**WELWYN HATFIELD ACCESS GROUP
HAZEL GROVE COMMUNITY CENTRE
HAZEL GROVE
WELWYN GARDEN CITY
HERTFORDSHIRE AL7 2DG**

re: Planning Applications Received by Welwyn Hatfield Council

Appn No.	Description and Location	Applicant
N6/2011/3120/DC3	Redevelopment of site to provide a wet play area, adventure play areas, an educational play area, high ropes attraction, changing huts, education room, café and toilet facilities and car park Splashlands Stanborough Road Welwyn Garden City Hertfordshire AL8 6XA	Mrs. S. Morgan Cracknell 9 Holyrood Street London SE1 2EL

Drawing No. AA – 001 Pavilion Plans

PAVILION BUILDING PROPOSED FLOOR PLAN

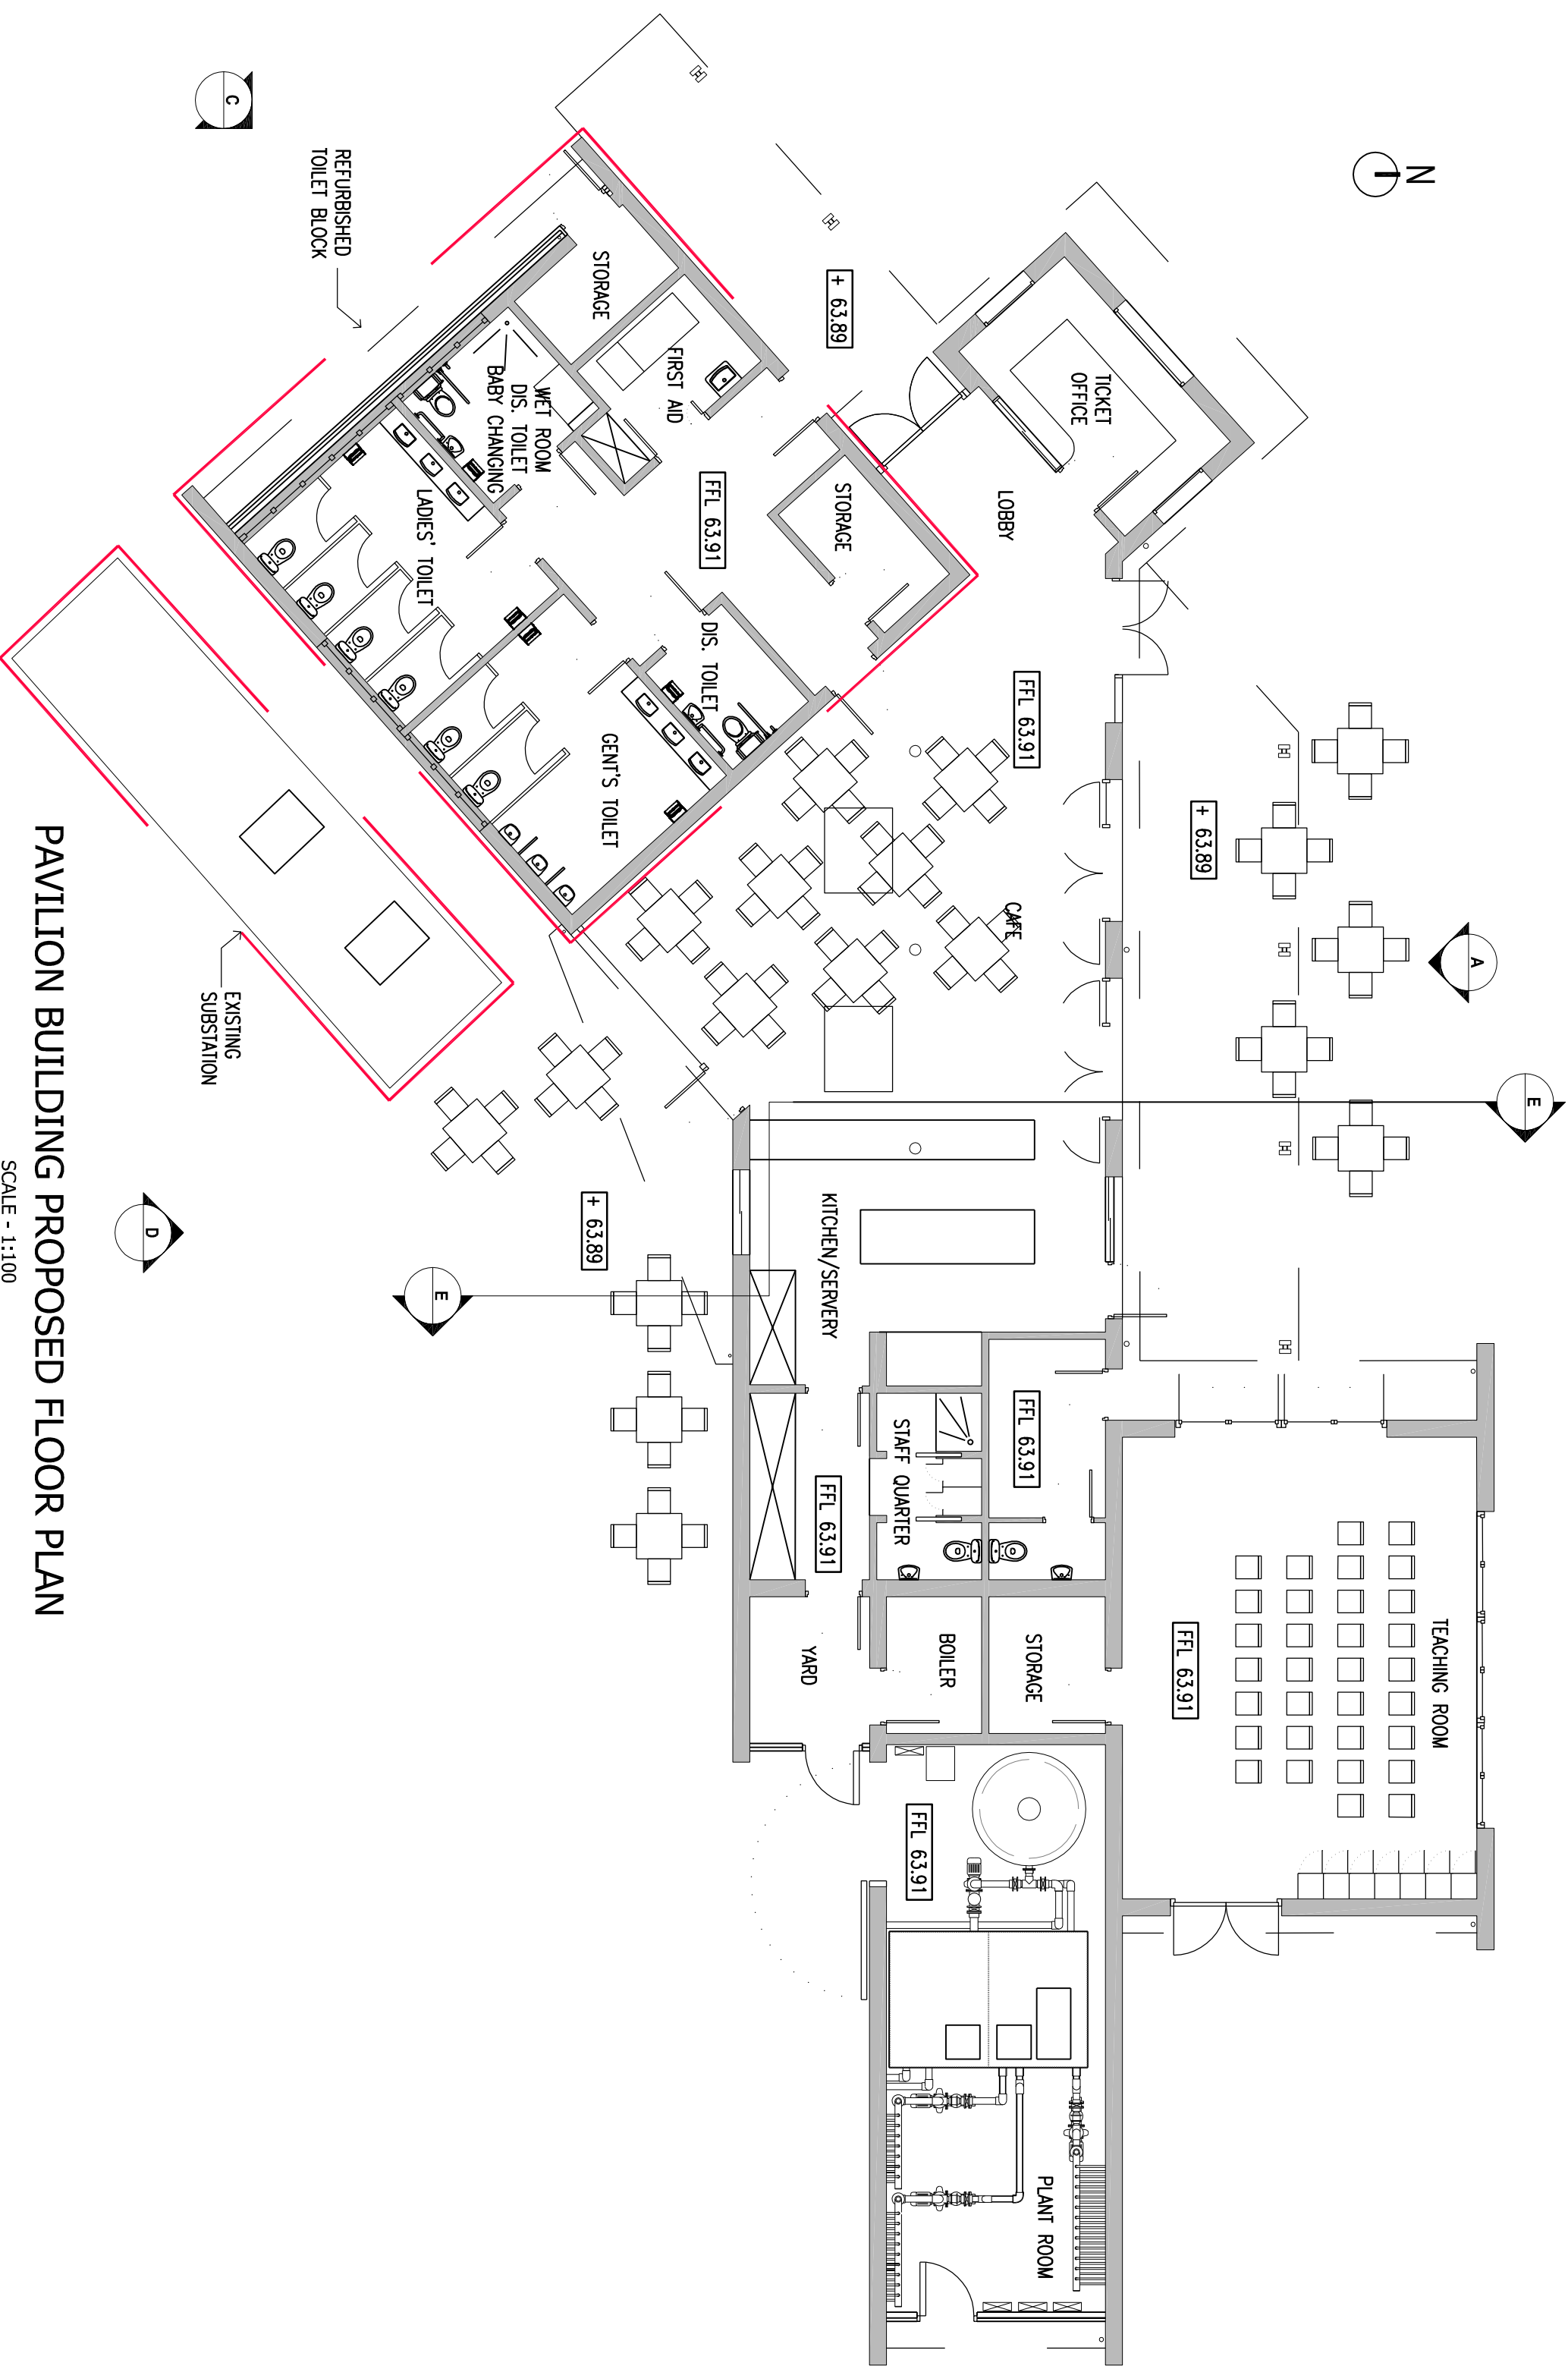
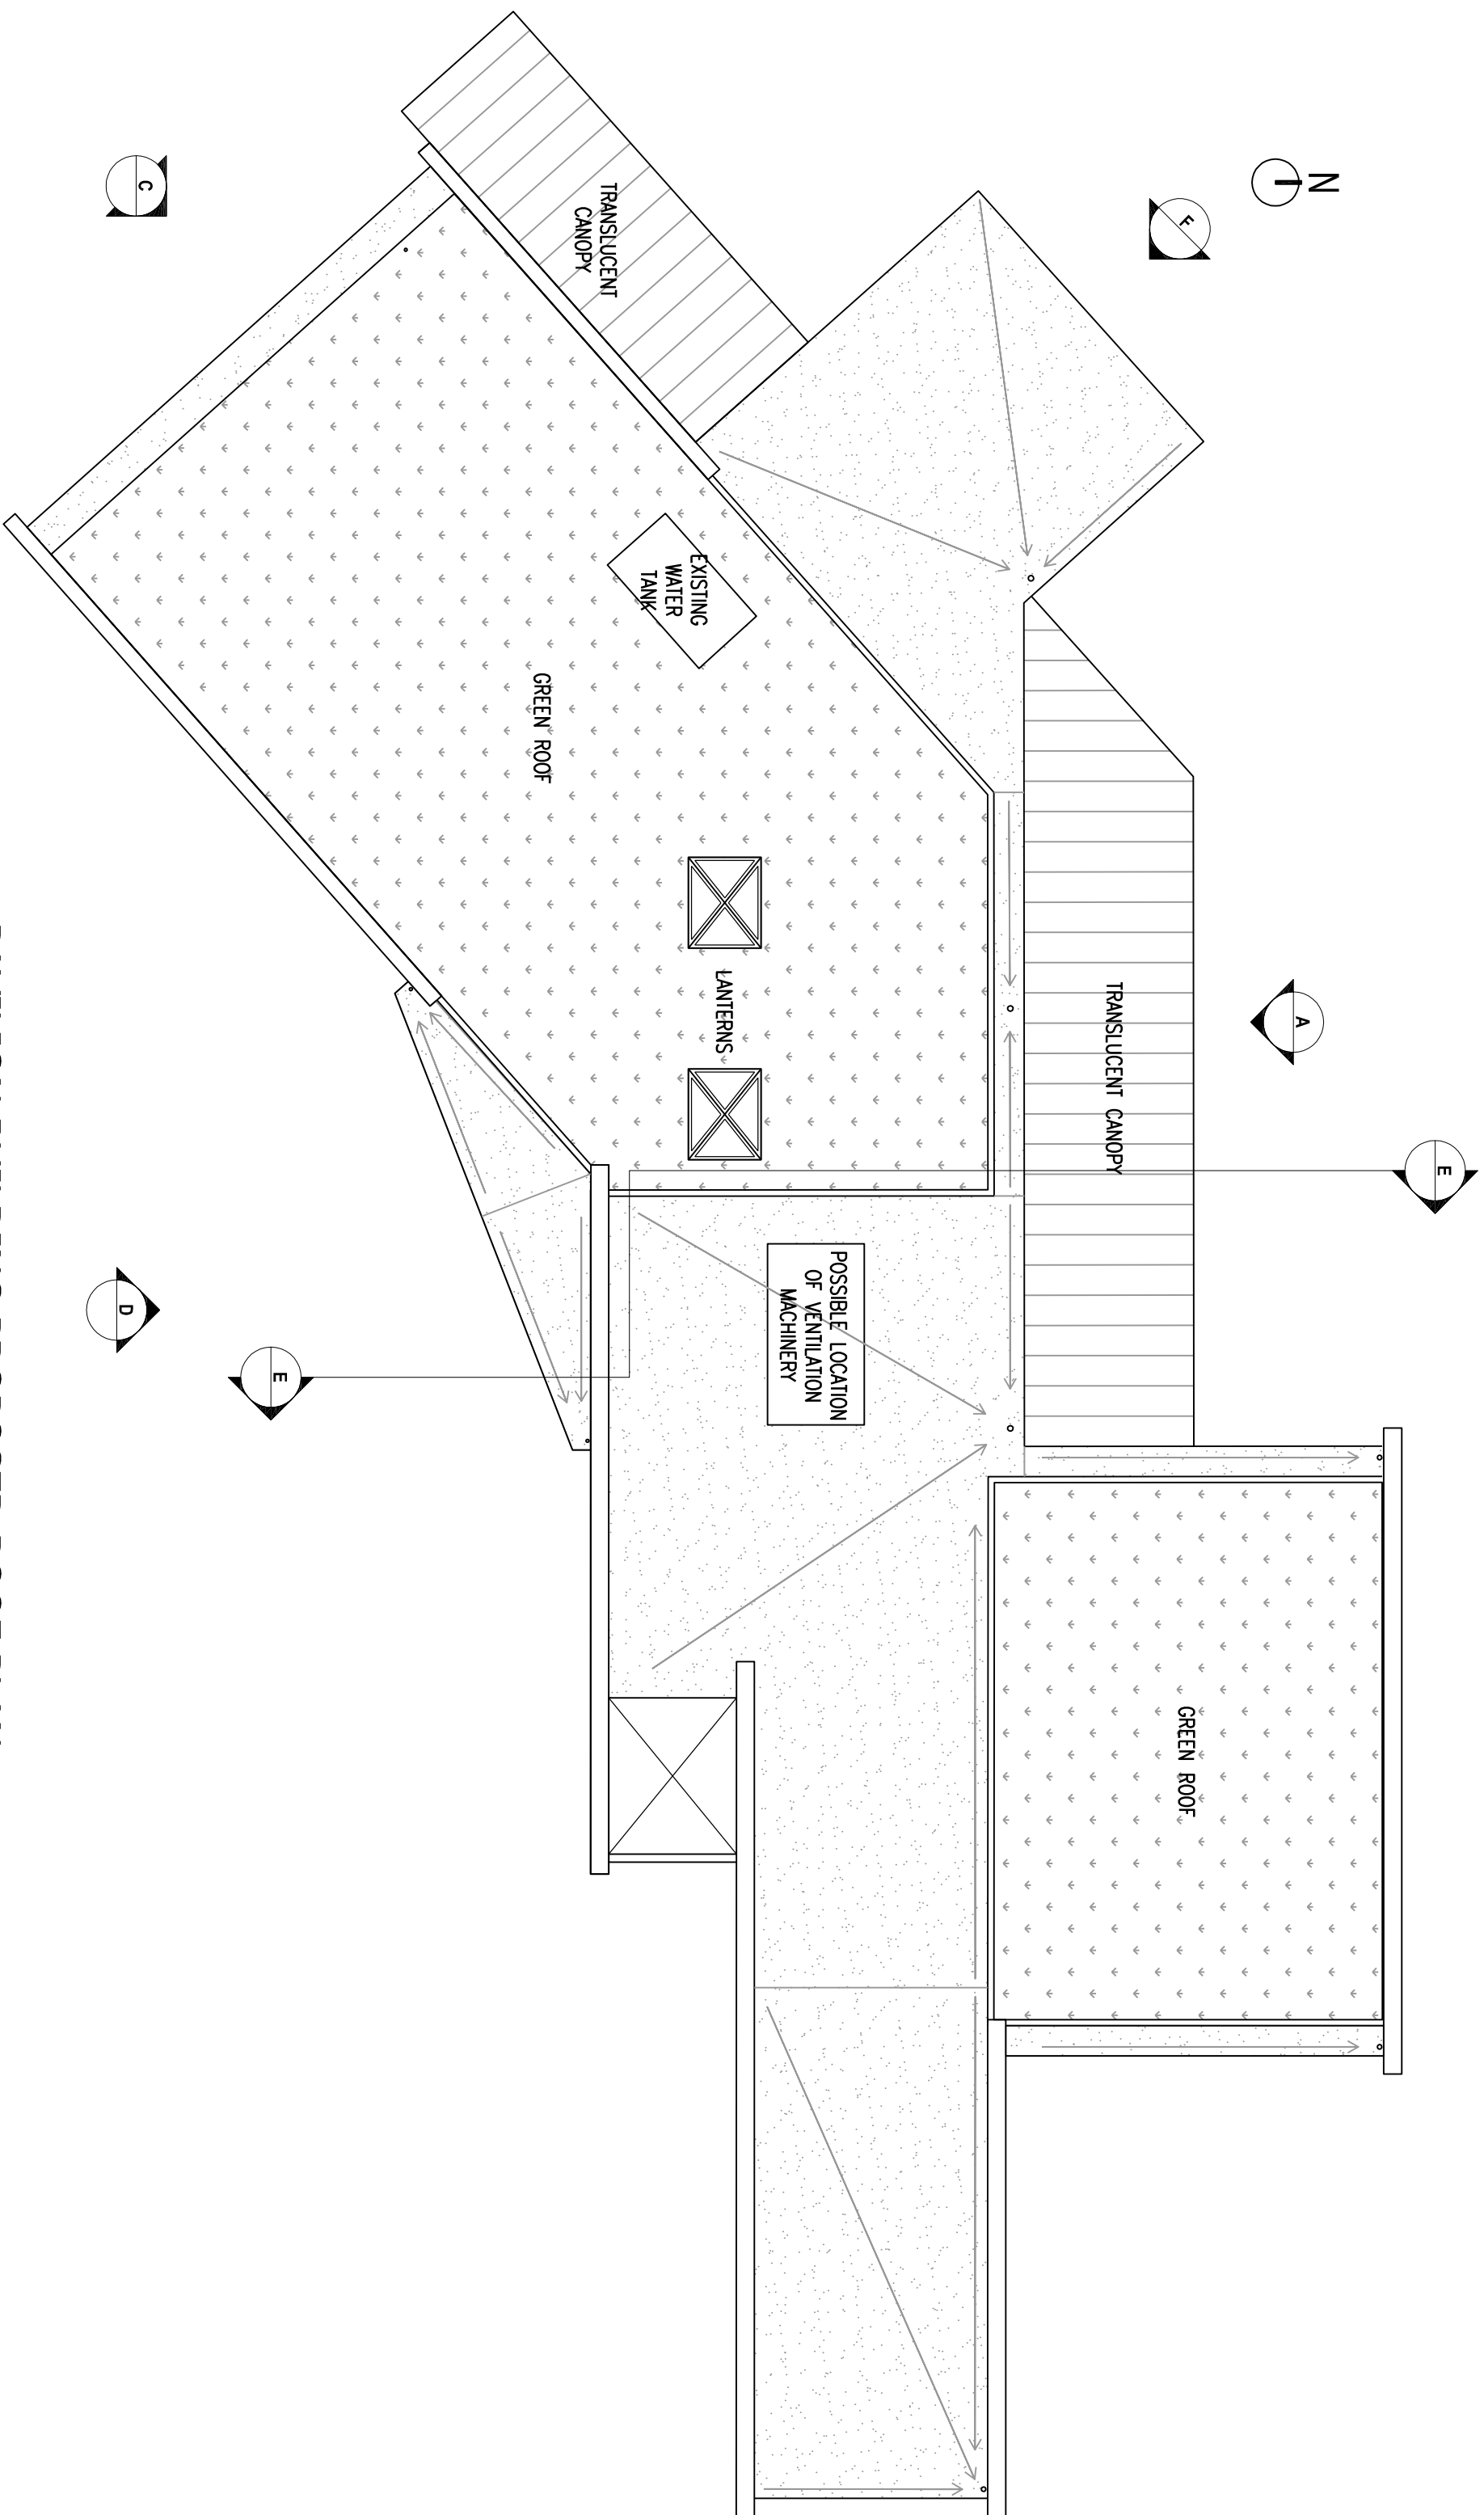
Toilet Block

This contains a unisex disabled toilet, separate Gent's and Lady's toilet blocks and a wet room incorporating a disabled toilet and a baby changing facility. Can you confirm: -

- i) that the dedicated Gent's and Lady's Toilet Blocks will include facilities for ambulant disabled
- ii) there will be low level urinals in the Gent's toilet for children's use.
- iii) the design of the wet room will allow for either a manual or overhead hoist and a fixed changing table as detailed in 12.7 'Changing Places sanitary accommodation' of BS8300:2009 'The design of buildings and their approaches to meet the needs of disabled people: Code of practice'

Teaching Room

After reviewing the drawings, we are unable to locate any toilets for those using the teaching room. We believe the distance required to travel from this room to the toilet block is too great for those with impairments.

Ticket Office

Would you please confirm if the entry doors to the complex are manual or automatic? From the drawing, we are unable to determine if the ticket office has a section of low counter for the use of height restricted or wheelchair users.

Refreshment Seating

From the drawing it appears these are fixed. As such, these are difficult to use for wheelchair users and those with impaired mobility. Can we suggest a mixture of fixed and movable seating is provided.
